Conservation Consultation Response:

From: Ian Heywood Planning Conservation Officer	To: DM Case Officer
Application no.	23/00748/FUL
Location	Fellcross Barn Cross Hill Farm Oakenclough Road Nether Wyresdale Scorton Preston Lancashire PR3 1DH
Description	Change of use of part of outbuilding to additional ancillary residential accommodation with change of use of land to domestic curtilage to allow the realignment of the domestic boundary
Date	23.08.2023

FRONT ELEVATION AS PROPOSED 1:100

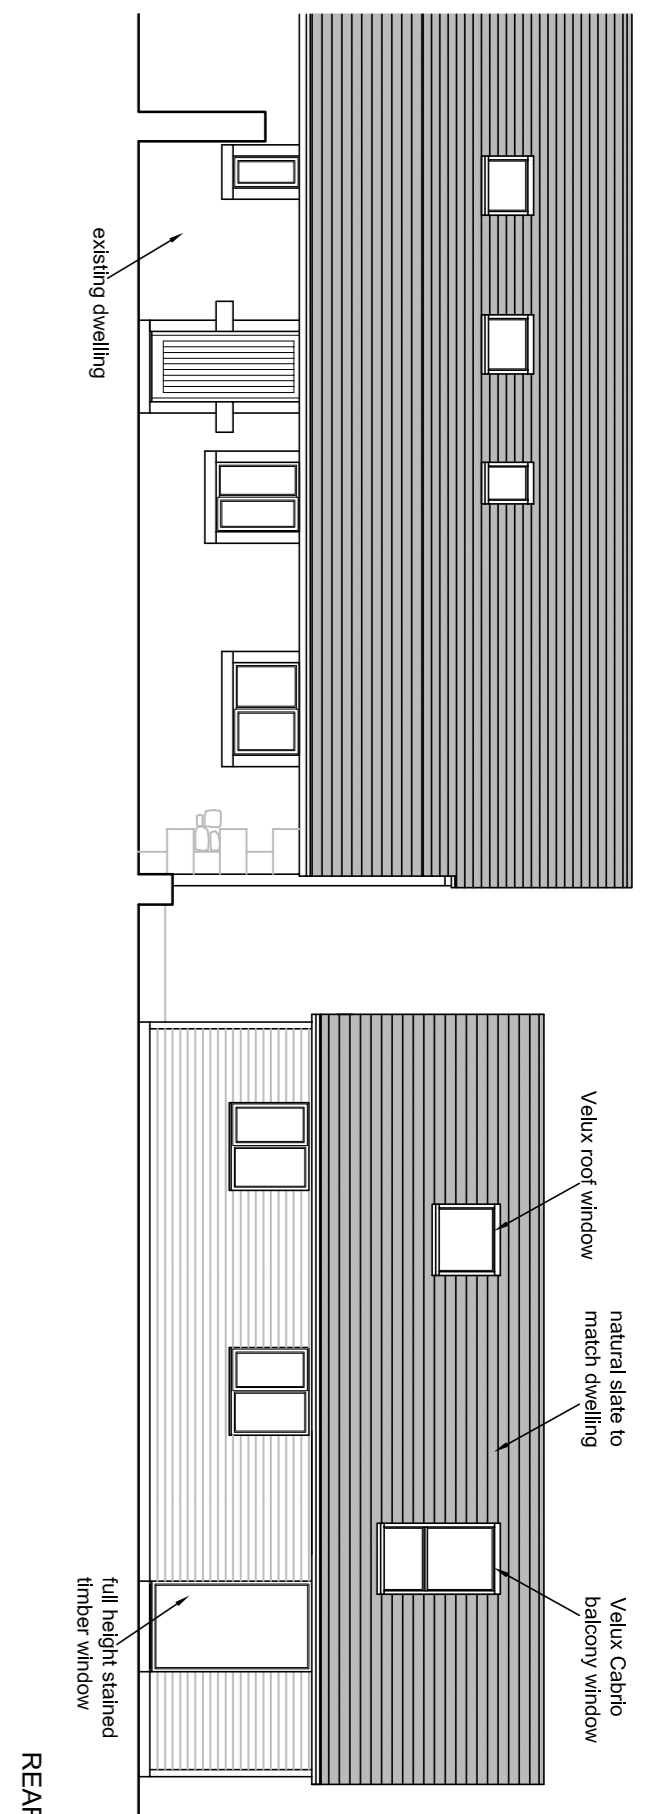
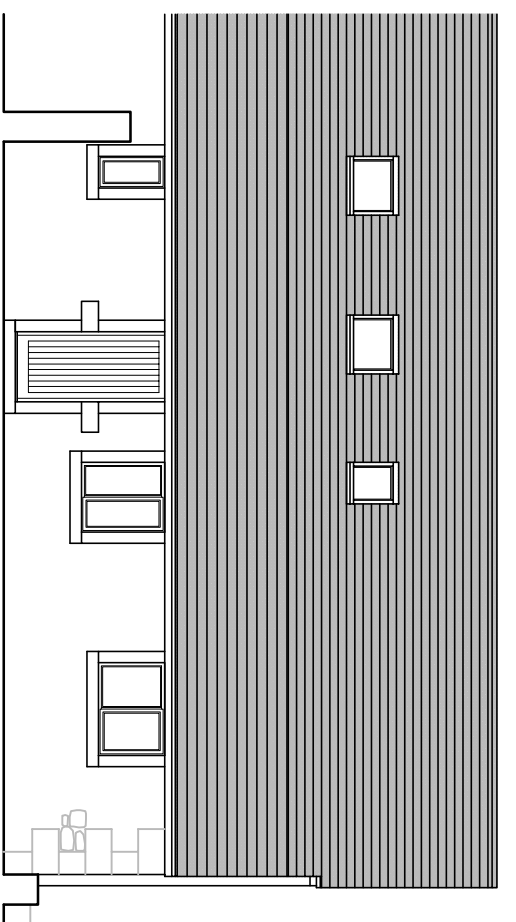
The detail alterations to the existing building are considered to be unacceptable, namely the change from two open-fronted garages to a single double-width modern garage door and the change of the current timber pedestrian entrance door to a modern design. These alterations are considered to be harmful to the setting of the listed building and to be unsympathetic to the design of the current building.

The harm that would be caused, whilst less than substantial, is considered to cause sufficient harm to be unacceptable. To rectify this, and make the application acceptable, the single timber pedestrian door should be retained and two single timber garage doors should be substituted for the currently proposed double-width garage door.
